IPD-22-580 – SHAW LANE, CARLTON, BARNESLEY.

ROAD SAFETY AUDIT – STAGE ONE DESIGNER’S RESPONSE REPORT.

Project Information	
Infrastructure Planning and Design Ltd. The Hayloft Barn Borough Hill Farm Walton-on-Trent Derbyshire DE12 8LL Tel: 01283 716869 Mob: info@ipd-ltd.com	
Job No.	IPD-22-580
Report No.	R.001
Prepared By	BO / SEF
Checked By	CLP
Approved By	RNP
Status	FINAL
Issue No.	-
Date	16.02.2023

## Drawing 1 - Shaw Lane Junction

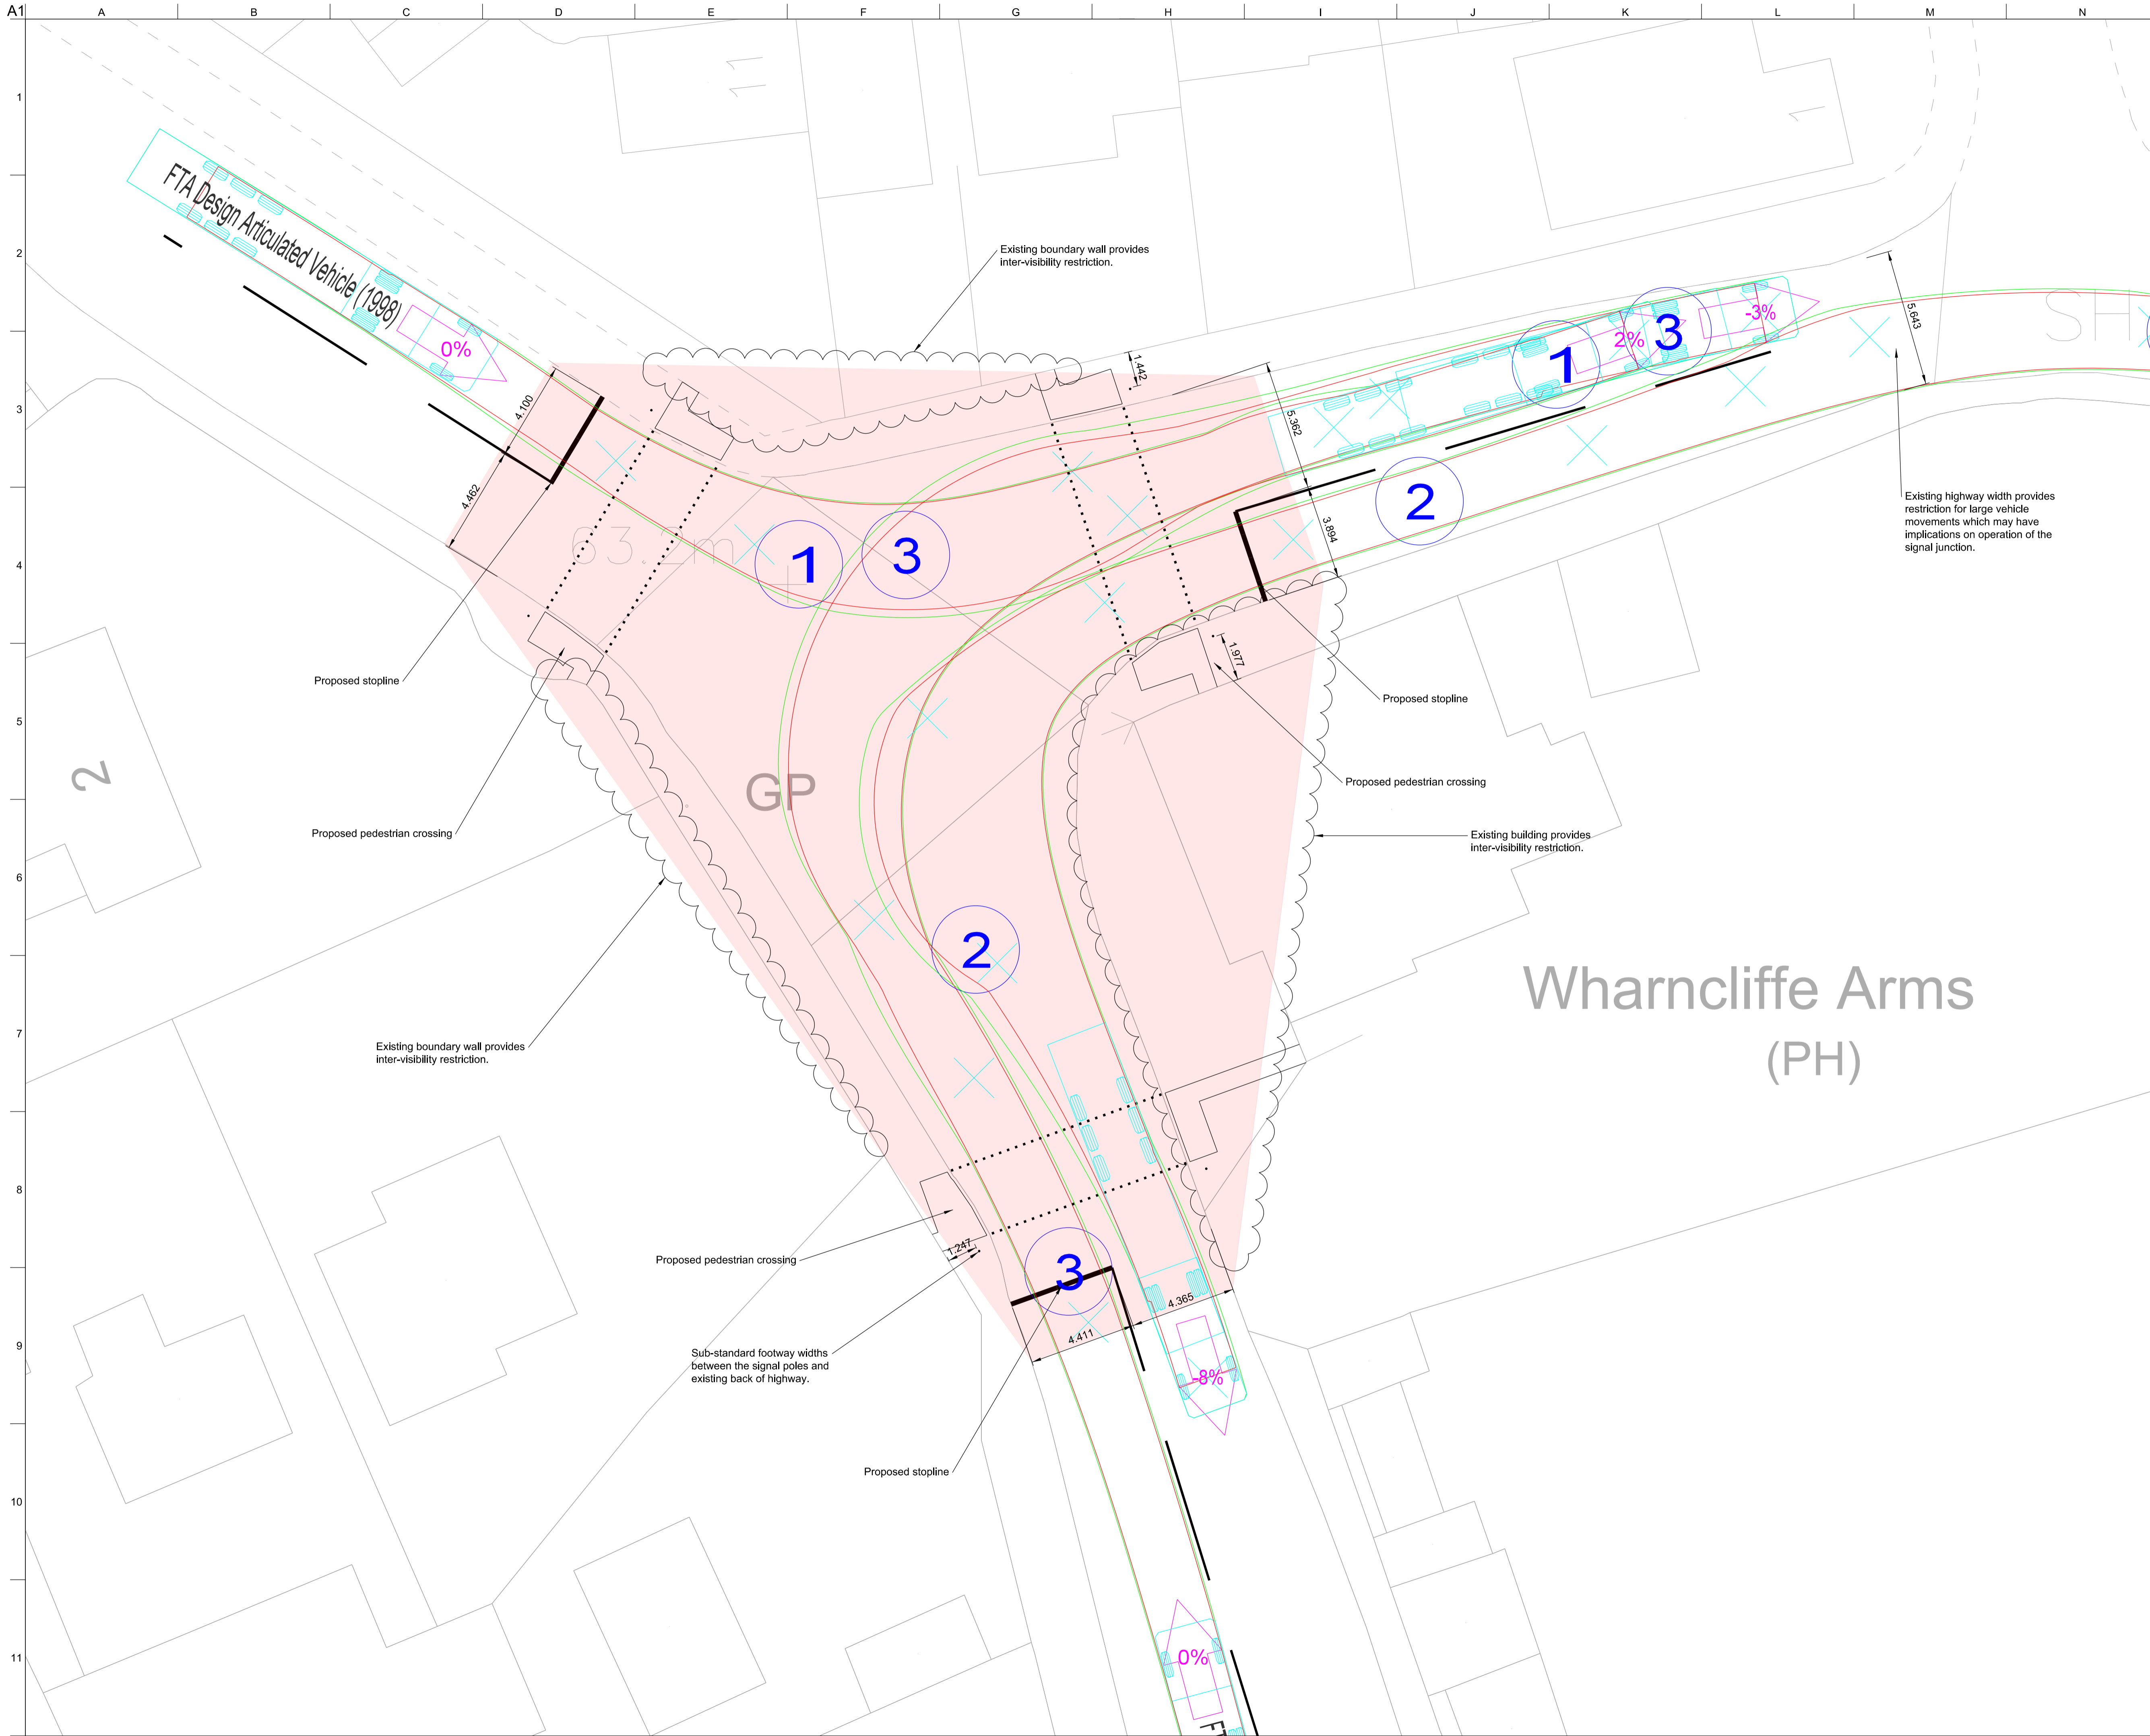
- 3.4 *PROBLEM 4-* "There is a risk that left-turning HGVs from Shaw Lane could potentially conflict with queuing traffic along Fish Dam Lane, resulting in them encroaching onto the footway at the south-eastern corner and potentially conflicting with pedestrians. Such a manoeuvre may result in injury to pedestrians or a collision with waiting vehicles."

"It is recommended that the designer carries out swept path analysis to ensure that the HGV turning manoeuvre can be accommodated within the carriageway and without encroaching into the northbound lane of Fish Dam Lane."

"Swept path analysis of an Articulated 16.5m vehicle has already been undertaken on this junction. The swept paths can be found under drawing ref: IPD-22-580-104 which shows the vehicle can manoeuvre around the junction adequately."
